COLORADO
Department of Transportation
Region 2

Access Permit No. **222165/166**
85-87/El Paso County

RE: Bradley Point Site Development Plan

BRADLEY POINT FILING NO. 1-DRY SUBDIVISION SITE DEVELOPMENT PLAN

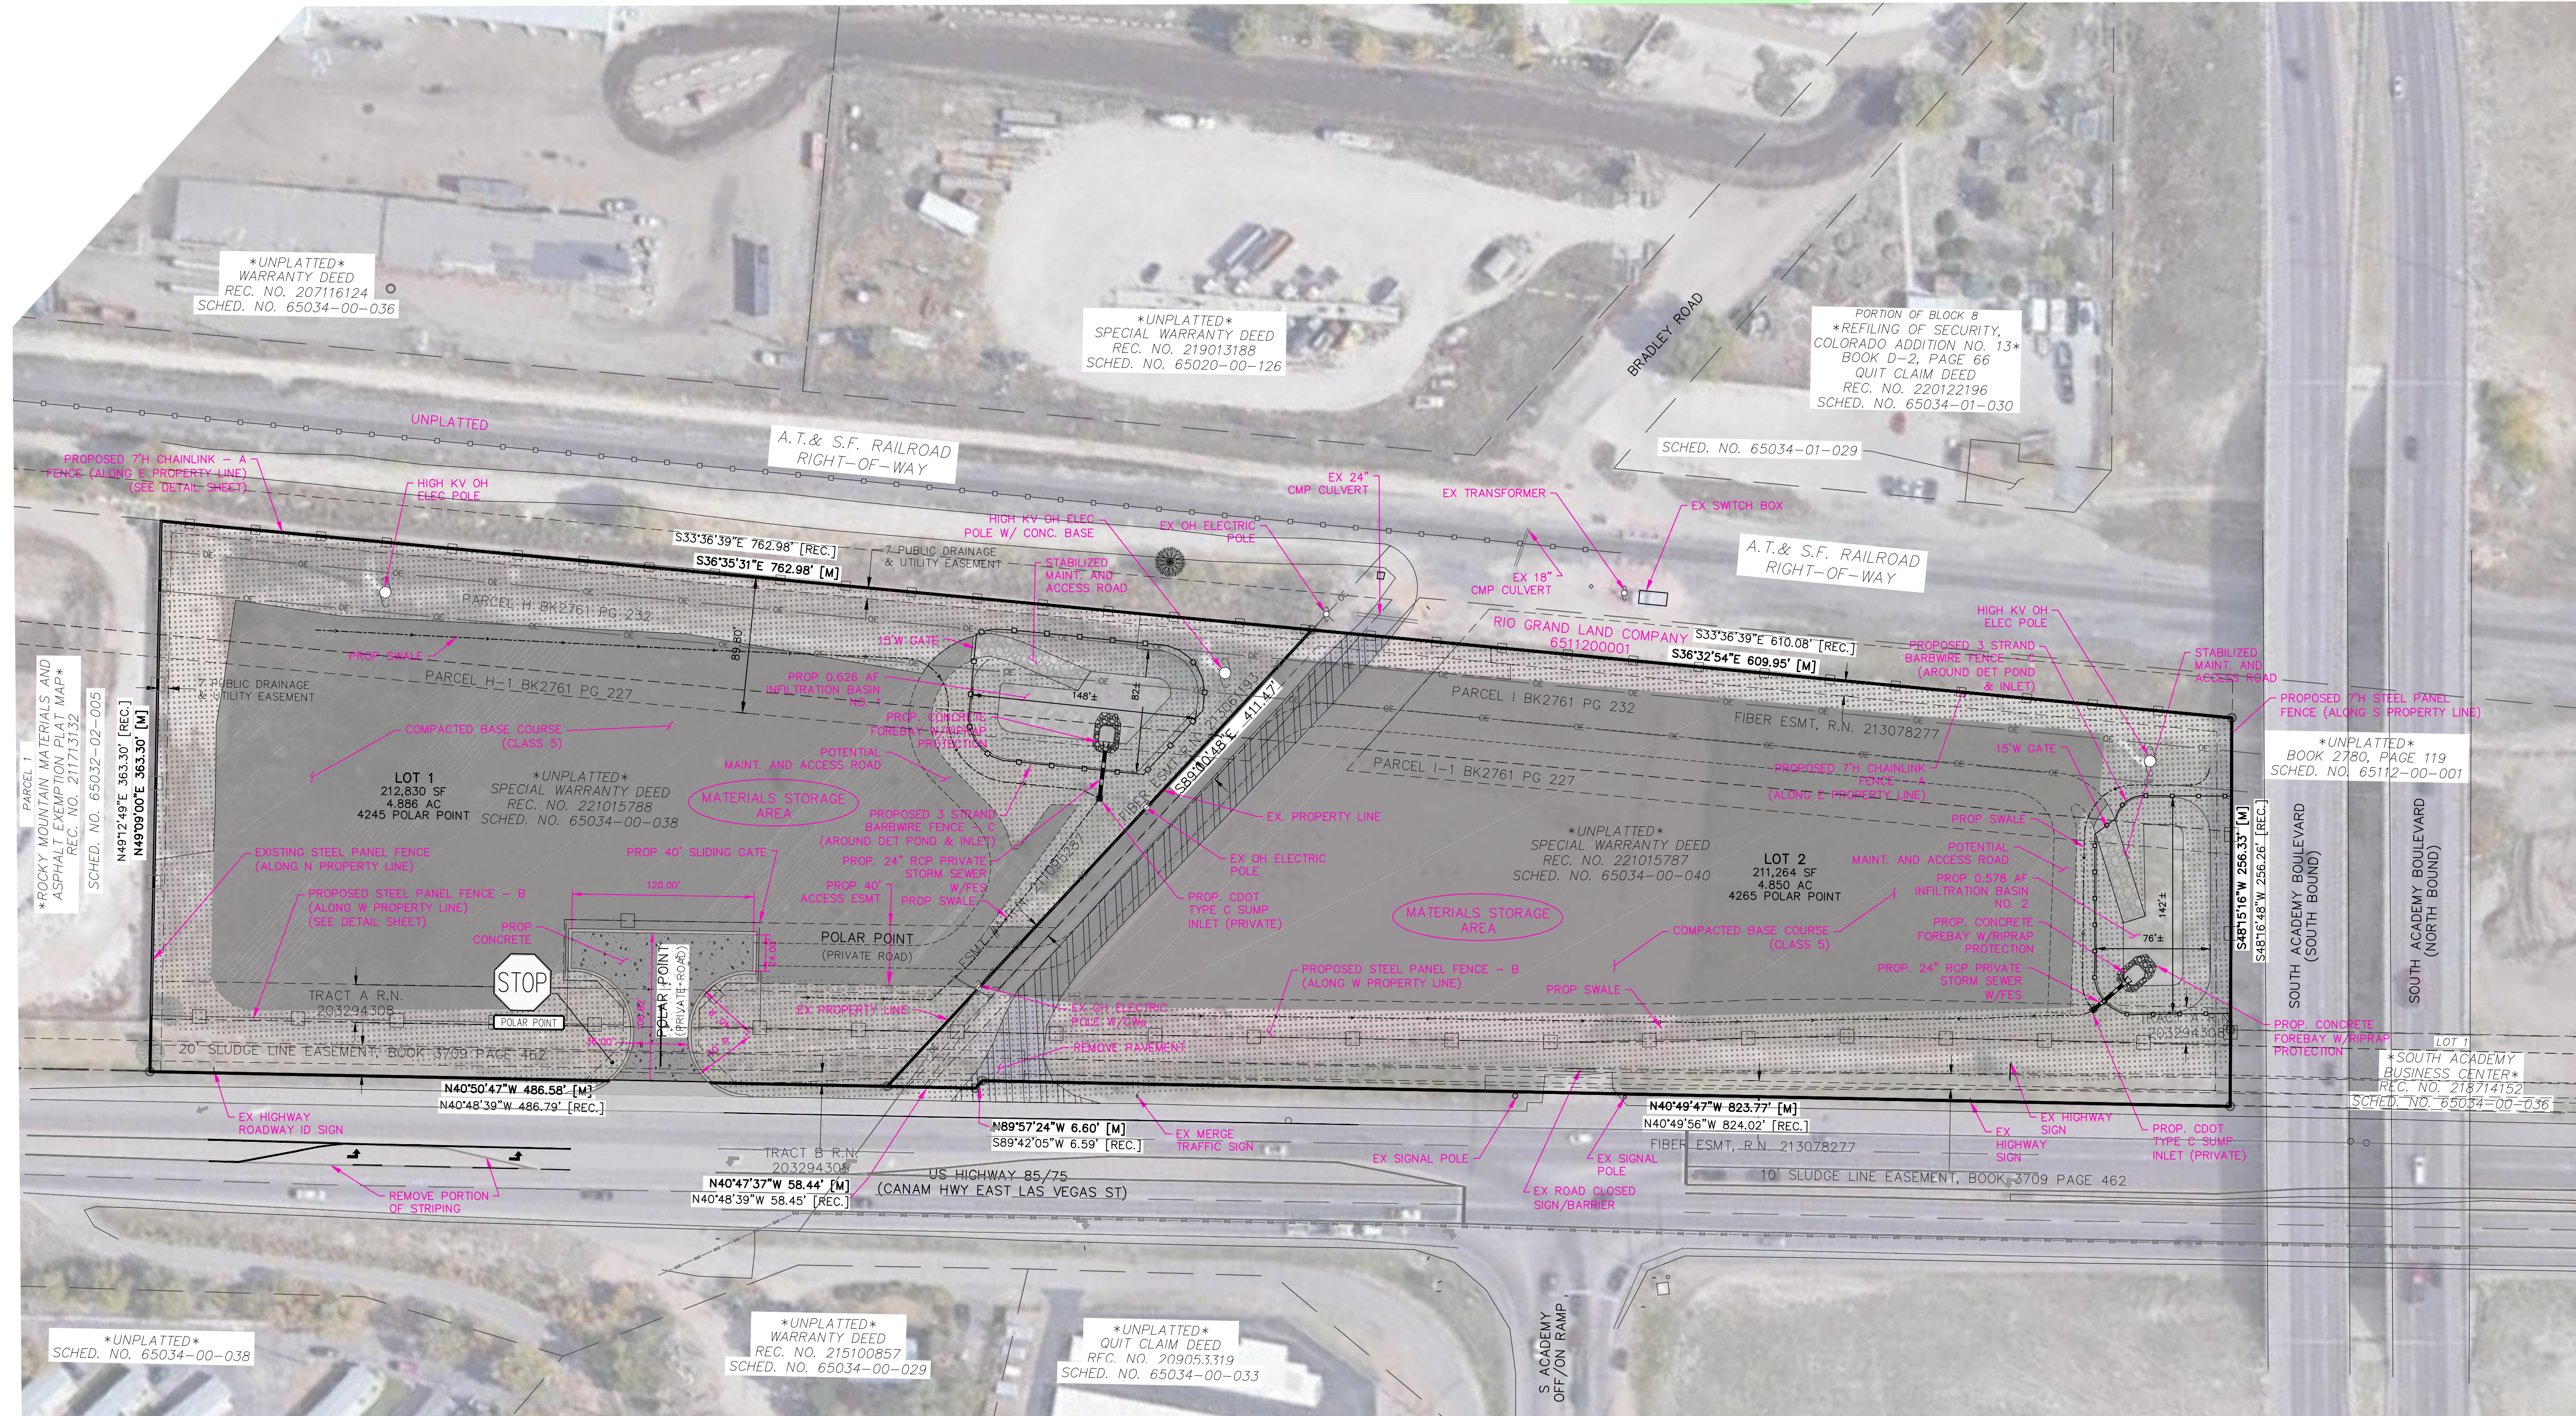
- As a condition of the access permit the permittee will be required to re-stripe a southbound left turn deceleration lane into the site where the existing painted median exists.
